Comment for planning application 18/00825/HYBRID

Application Number 18/00825/HYBRID

Location Heyford Park Camp Road Upper Heyford Bicester OX25 5HD

FIGURE 2

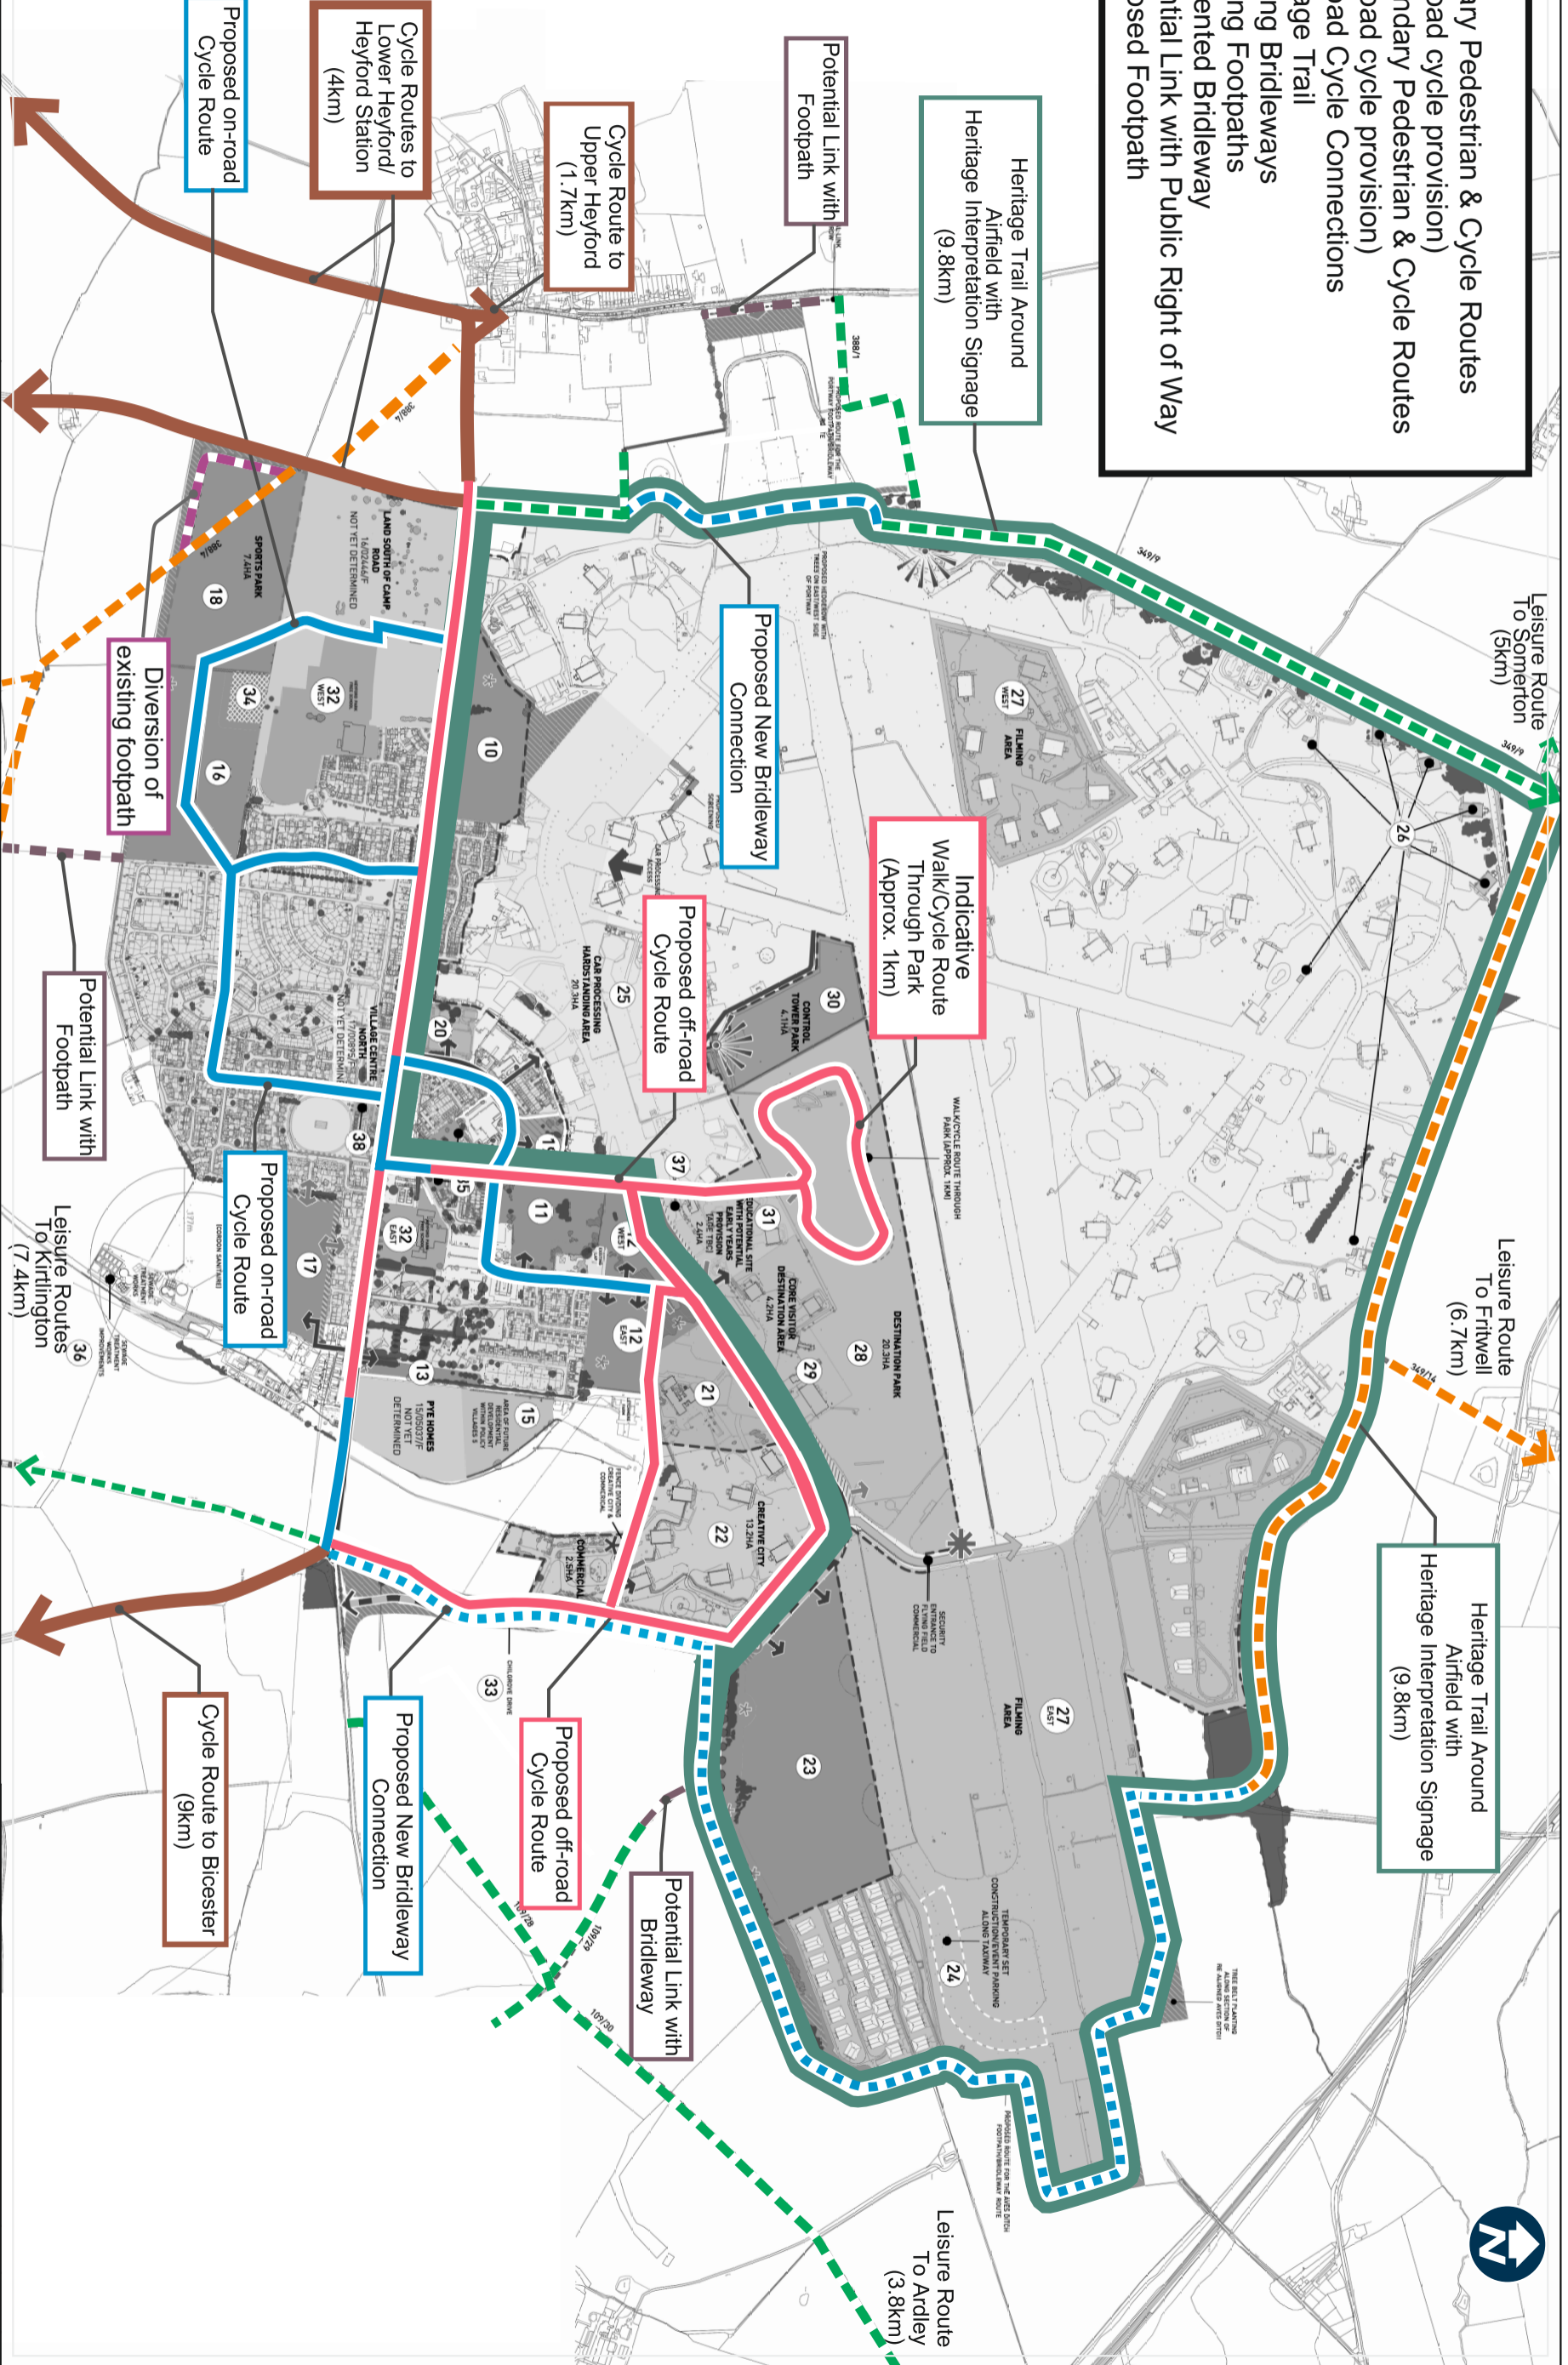
Comments Figure 6.2b Ped Cycle route . As a supporter of footpaths and bridleways which provide a connection between the villages there should be more research done into the connections between Heyford park and the surrounding localities and the connections of the Heritage Trail are not clear. A footpath is a PROW so why is the footpath not labelled on the map where it has been marked before - please could the reason for this be clarified . TN305 Reassessment of Heyford park and Middleton Stoney Bus Gate. I object to the planning of the bus gate as it will only push the traffic congestion down the road to Somerton with its blind entrances ,narrow road , hump back bridge, little pavement for pedestrians and sid so extra money from S106 although welcome may not reduce the number of vehicles . Mitigation proposed in the traffic report is to be focused on "discouraging through traffic from using this route" but where will it be encouraged to go ? The survey surprisingly did not include the interconnecting Ardley Somerton rd and with the new Ardley junction the traffic will increase along this narrow old cart road to the M40? A34 . A reduced speed to 40 mph and weight restriction (not agric vehicles) is very much needed . This is a massive planning application in a lovely area of Oxfordshire which will provide much needed employment and homes but it is a difficult time for discussion and research so I hope more time may be given to work on the important living points above . Thankyou
